**Re: Academy Dental Center
6421 Holly Ave NE
Request for Certificate of Occupancy
Transportation Development Final Inspection
Engineer's/Architect's Stamp dated 4-3-20 (C18D038A)
Certification dated 8-24-20**

Based upon the information provided in your submittal received 8-24-20, Transportation Development cannot approve the release of Certificate of Occupancy for the above referenced project.

Site Plan
C1.0

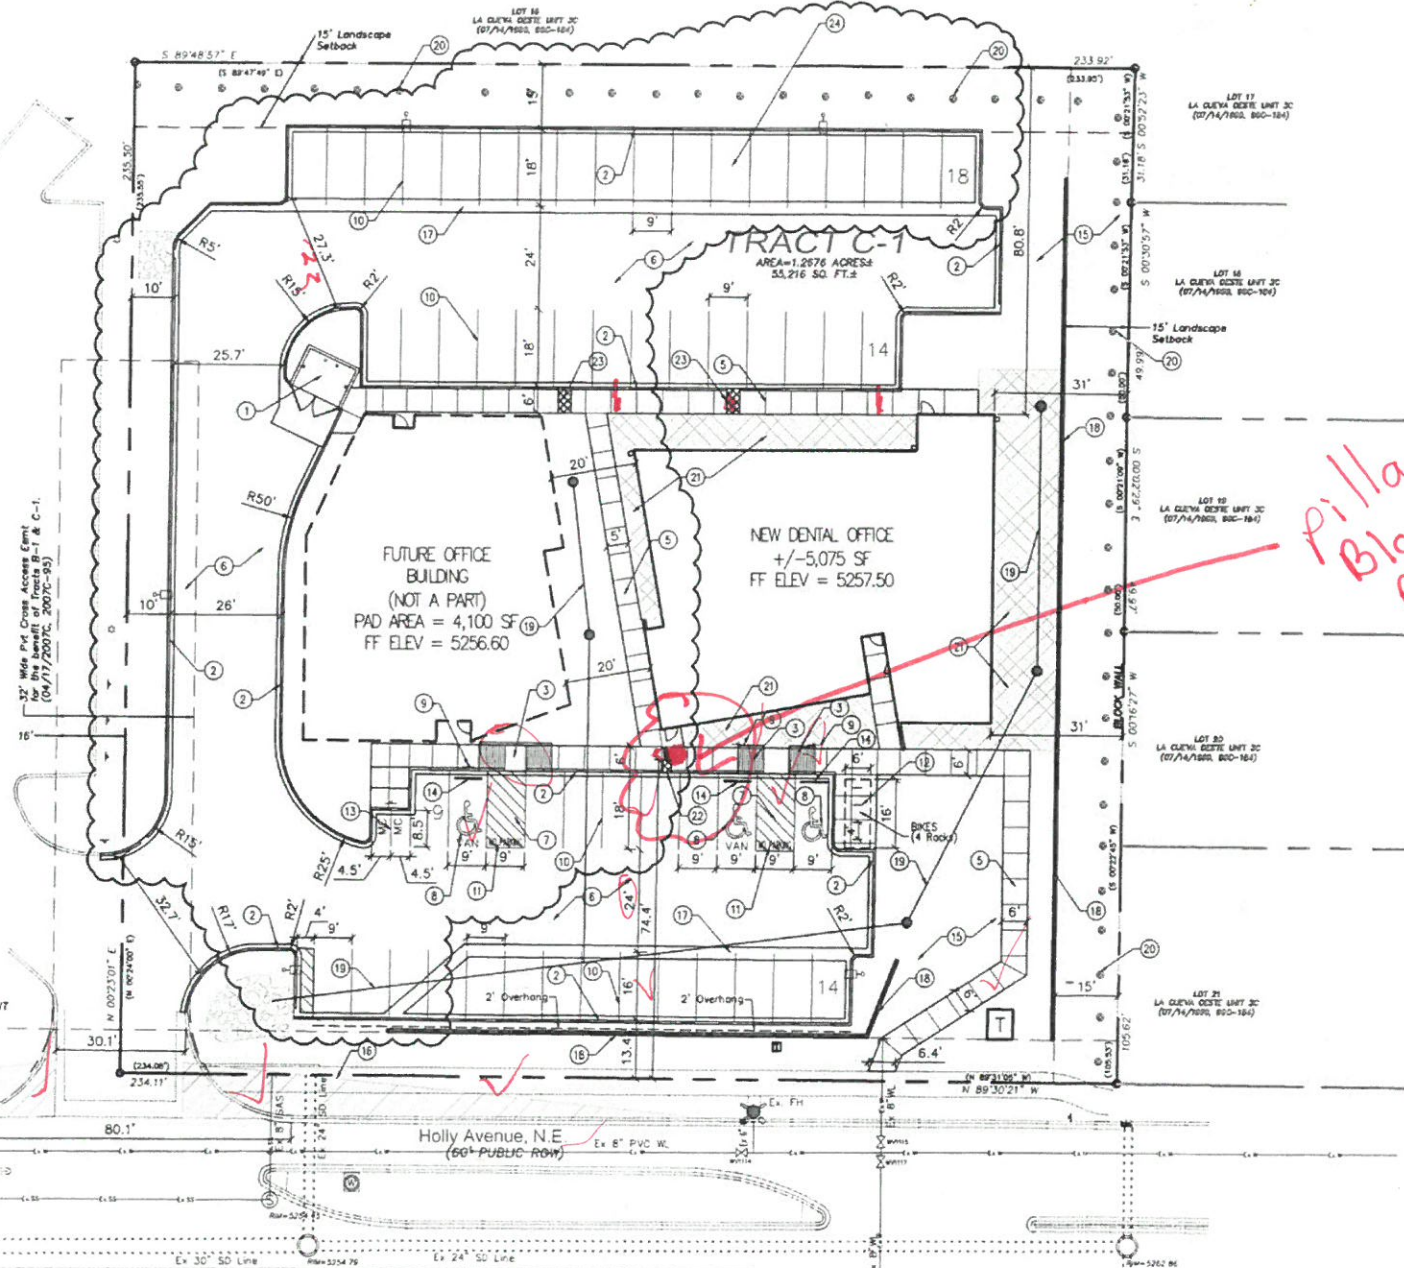
- Continuous 6 foot ADA pathway from sidewalk to the building entrances is obstructed. (See Attached Photos) Please design solution prior to release of Temp CO.
- Please add top plates to sidewalk culverts.
